I wish to lodge my strong objections to 2020/92209,

Case officer

Adam Walker

NORTH EAST ELEVATION (MAIN ENTRANCE)
SCALE 1:50

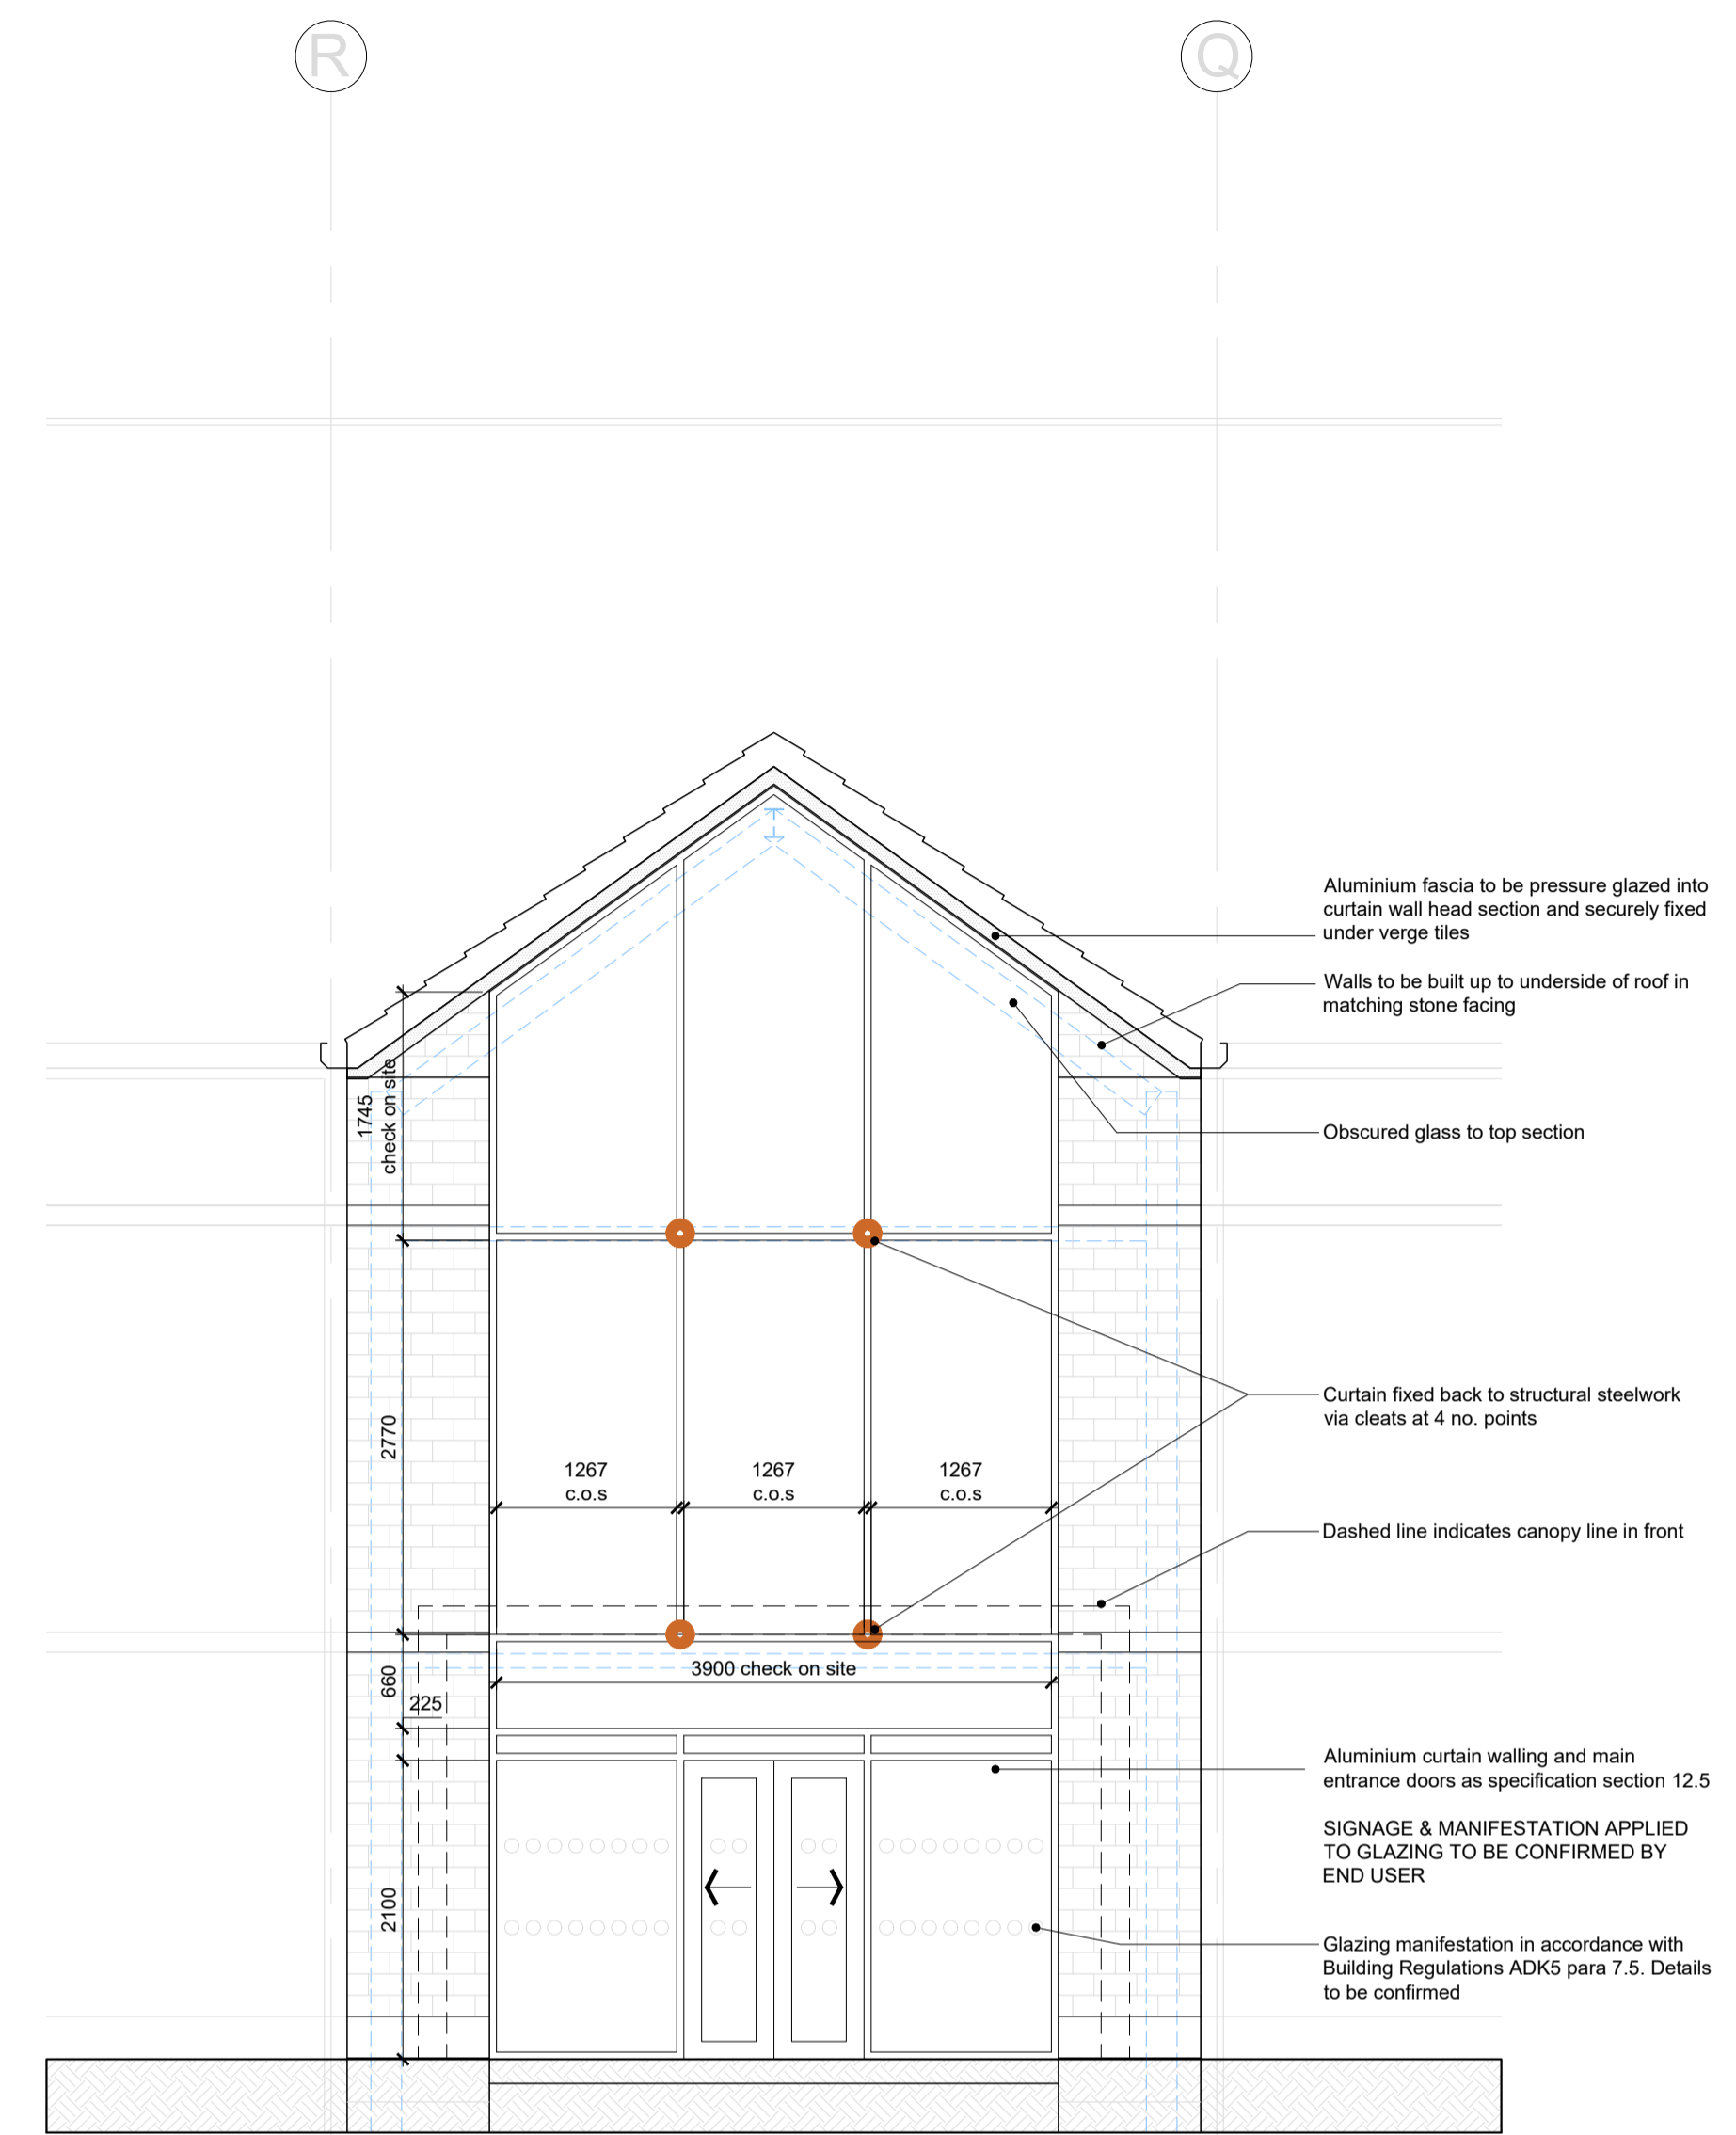
Noise and disturbance resulting from use of the new building: I have carried out acoustic noise calculations (see calculation sheet below) based upon the Air conditioning and Heat pump mechanical plant units installed externally along the Lower Gate side of the new building as specified in the 2020/92209 documentation. My calculations indicate that a noise level of **51 dB(A) at NSR Lower Gate** is predicted based upon the already installed air conditioning and heat pump mechanical plant units' manufacturer's published data

and the location / directivity / distance of the installed mechanical plant to NSR Lower Gate. Allowing a 12db open window loss would give a level of 39 dB(A) inside front upstairs bedroom but that presumes the Lower Gate residents don't make use of their front yards which I know they do. The heat pump is the noisiest unit with a manufacturer's quoted *Sound Pressure level* of 66 dB(A) at 1 metre. Calculating *conformal radiating surface area* at 1m (correction of 15dB) produces 81 dB(A) *L_w Sound Power Level* for Mitsubishi 560KXZE1 Heat pump. All other units published manufacturers data are quoted as Sound Power Levels. Mitsubishi FDC200VSA 74 dB(A)*L_w* single unit (6 installed). Mitsubishi SRC35ZMX-S 63 dB(A) *L_w* single unit (3 installed). The distances vary from unit to unit to NSR but 28 metres has been used as the attenuation distance as this is quoted in the Councils own document attached to planning permission 2017/93366.

The increase in roof height by over a metre and the subtle expansion of the building width via alterations to the curtain walls will in effect undo the attempt to reduce what is already a wholly inappropriate building in this location in terms of scale and mass. This increase in roof height and the expansion of the building width via alterations to the curtain walls and fenestration should not be permitted.

The proposed significant changes to the fenestration and the raising of the overall roof height by in excess of one metre as submitted would adversely impact upon the amenity of residents along Lower Gate and more particularly some of the back-to-back properties to the North along Longwood Road and is unsympathetic in overall mass, character and scale.

The fenestration changes further impact the privacy of neighbouring houses.

The proposal has an excessive number of poorly directed wall lights generating significant light pollution.
